Norfolk Boreas Offshore Wind Farm

Appendix 19.1

Norfolk Vanguard Ground Conditions and Contamination Consultation Responses

Applicant: Norfolk Boreas Limited
Document Reference: 6.3.19.1
RHDHV Reference: PB5640-006-1901
Pursuant to APFP Regulation: 5(2)(a)

**VATTENFALL** **Royal HaskoningDHV**  
Enhancing Society Together

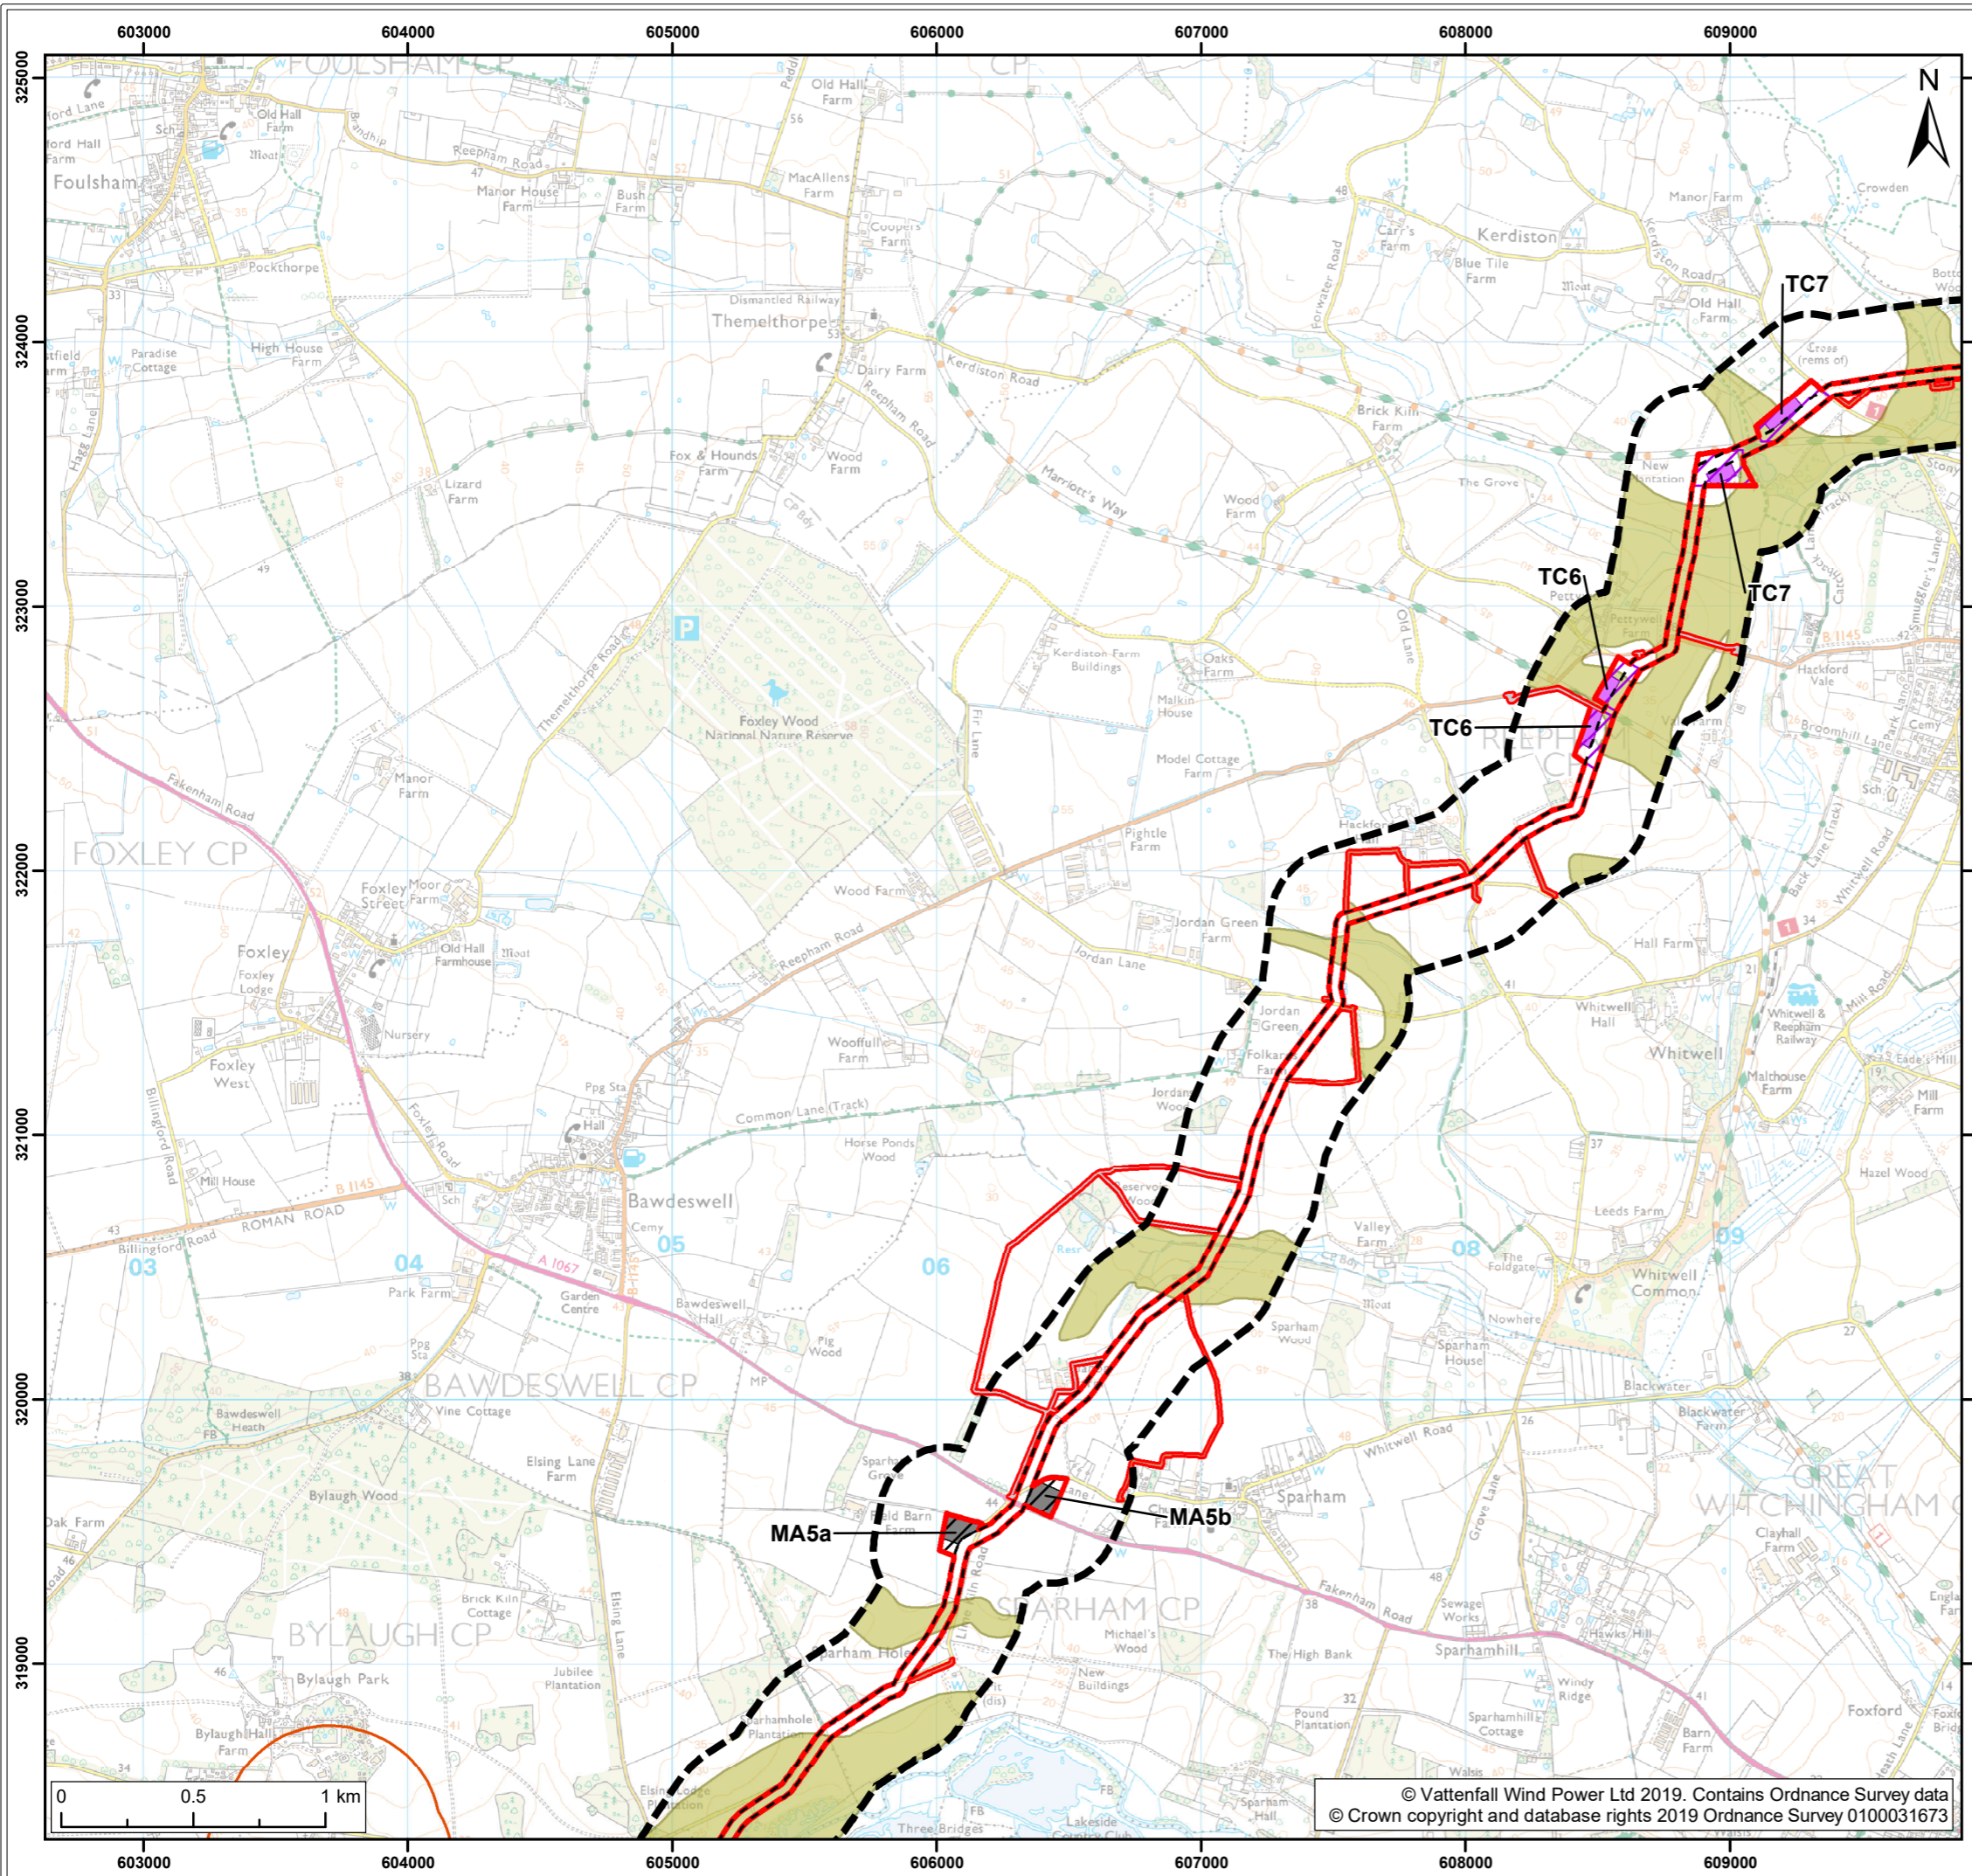
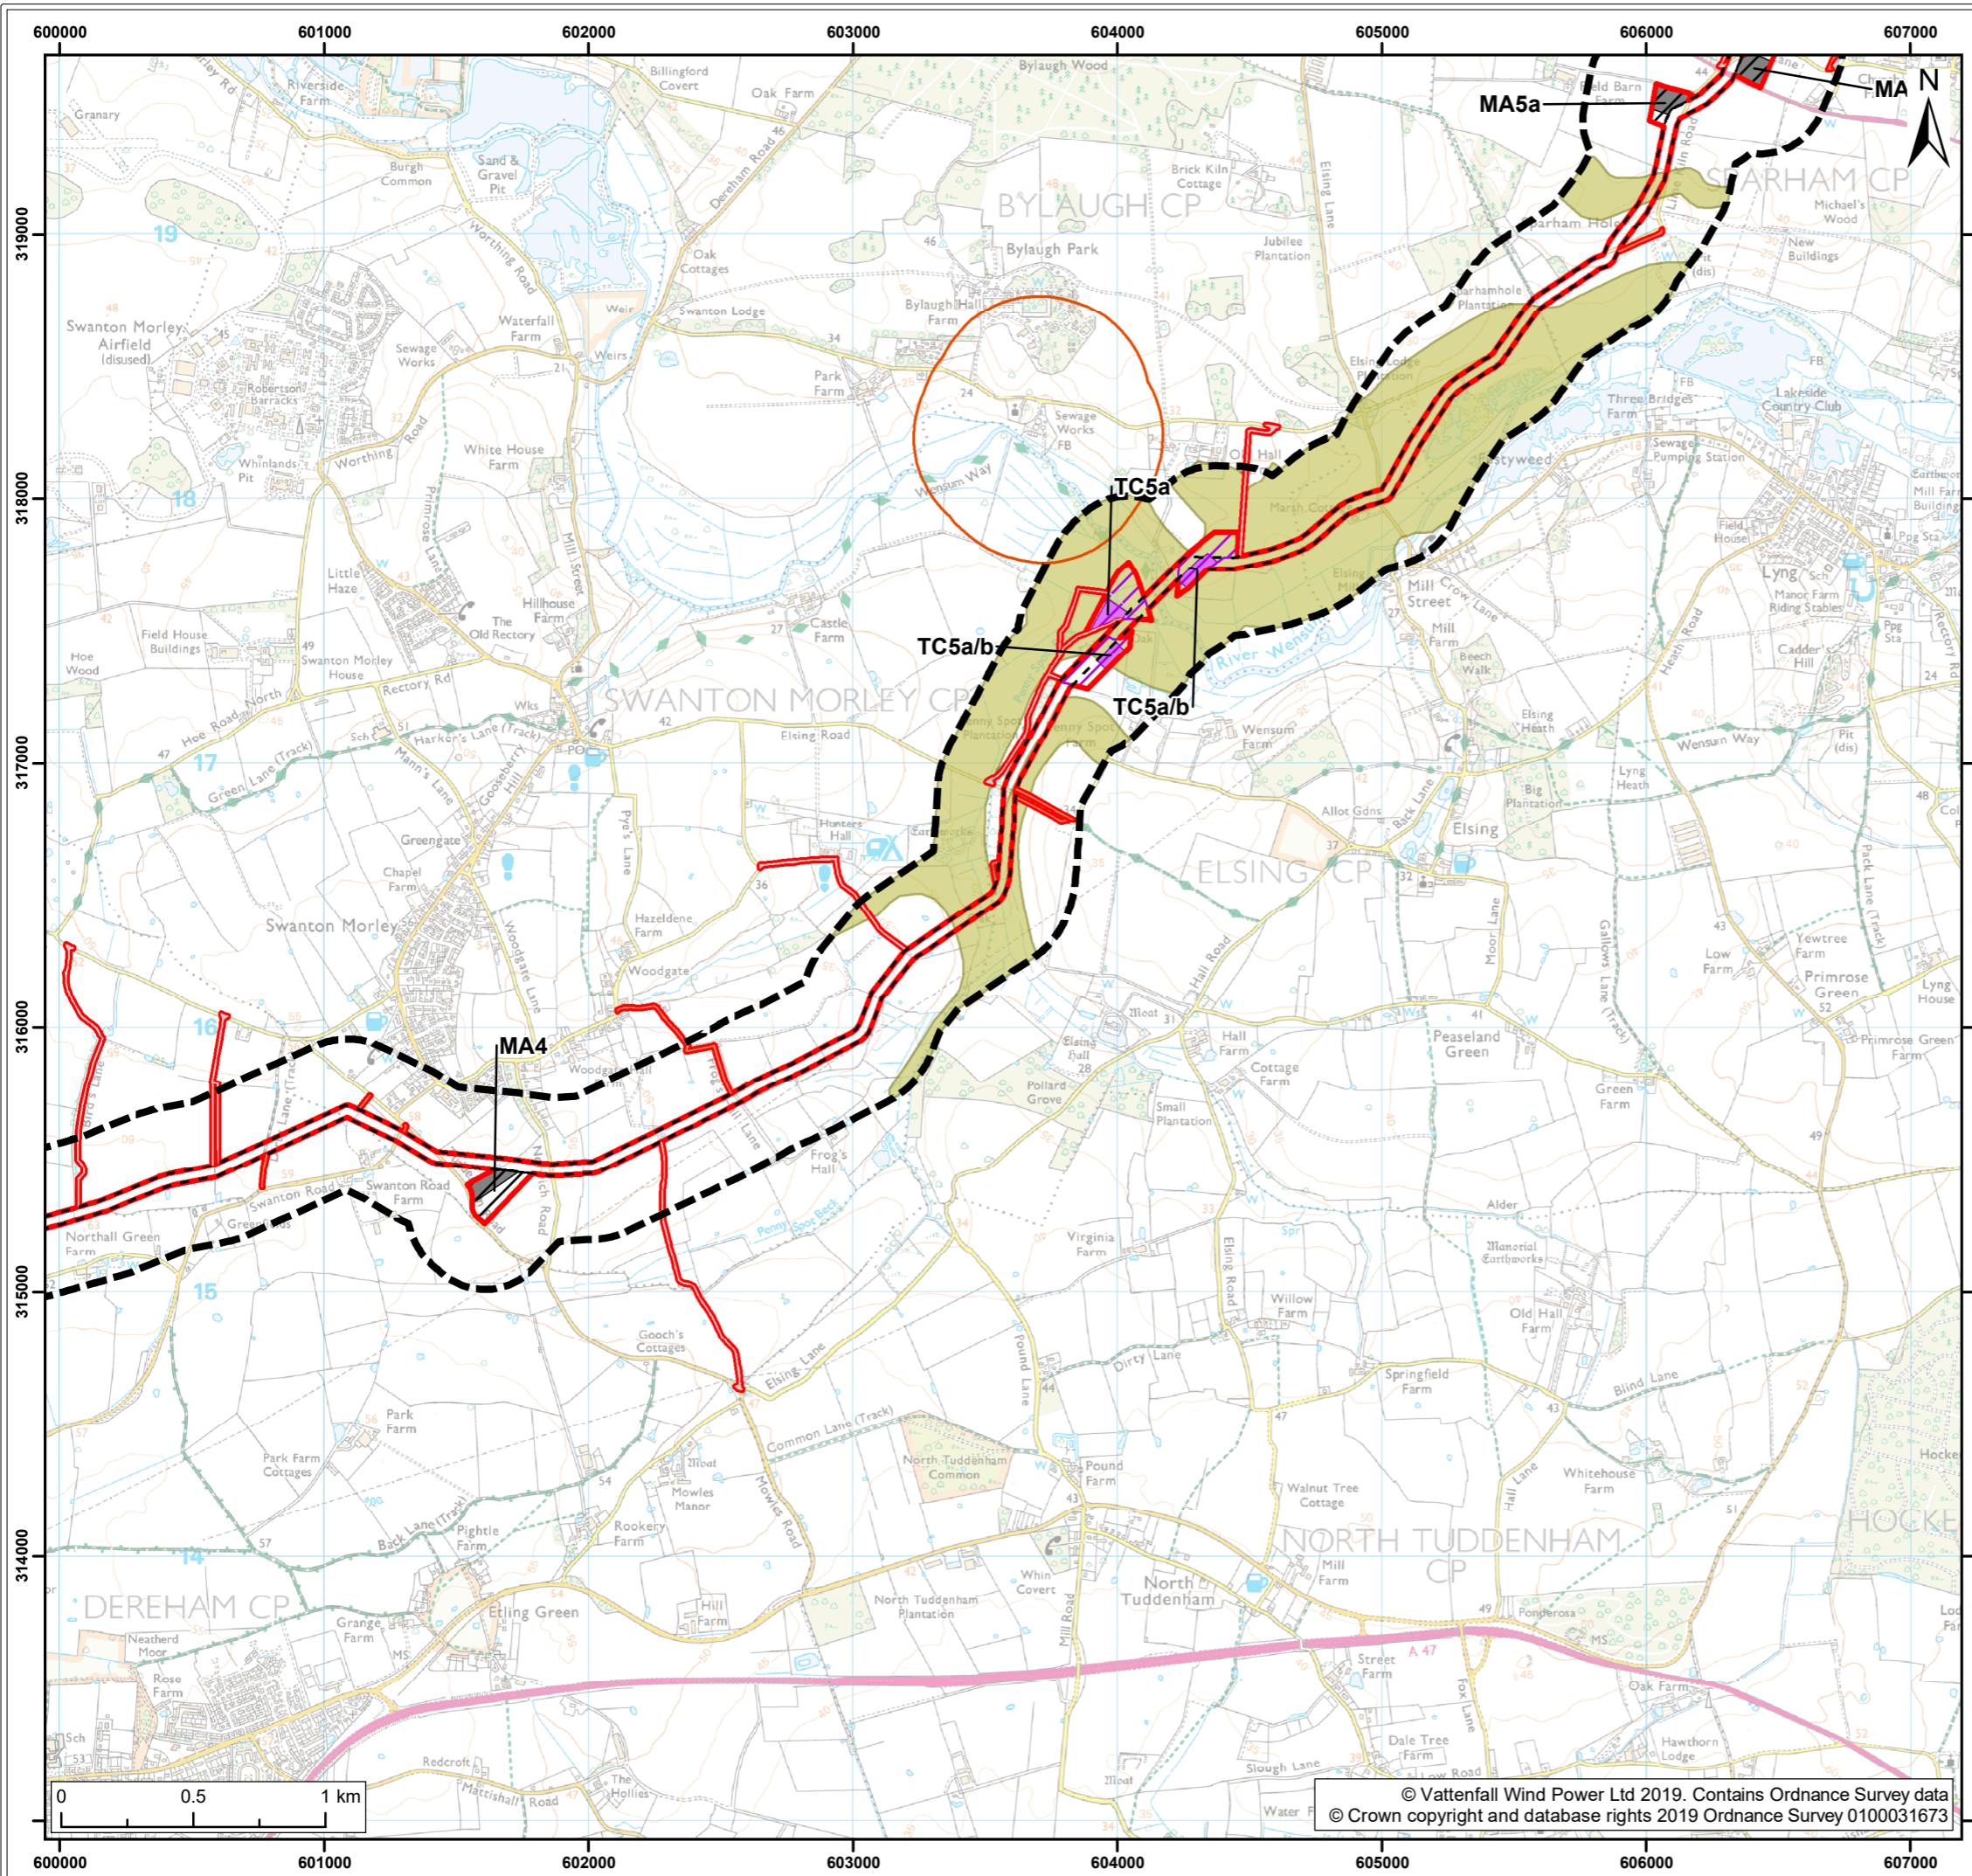
Consultee	Date /Document	Comment	Response / where addressed in the Norfolk Boreas ES Chapter 19
Secretary of State (SoS)	11 th November 2016 Scoping Opinion	The ES [Environmental Statement] should identify and assess potential impacts on the Mineral Safeguarding Areas underlying the onshore scoping area (see the comments of Norfolk County in Appendix 3 of this Opinion).	Mineral safeguarding data has been shared by Norfolk County Council and is considered within the assessment in sections 19.2 and 19.7.4.7.
SoS	11 th November 2016 Scoping Opinion	Paragraph 304 of the Scoping Report notes there is rapid cliff erosion on the coast of north east Norfolk. The potential impacts of landfall works on coastal processes, including erosion and deposition, should be addressed with appropriate cross reference to other technical reports including landscape and visual impacts. Reference should be made to the Kelling to Lowestoft Ness Shoreline Management Plan, where appropriate.	Rapid cliff erosion on the coast of north east Norfolk is considered within the assessment in sections 19.6 and 19.7.4.1. Appendix 4.5 Coastal Erosion Study of Chapter 4 Site Selection and Assessment of Alternatives also provides information in relation to coastal erosion.
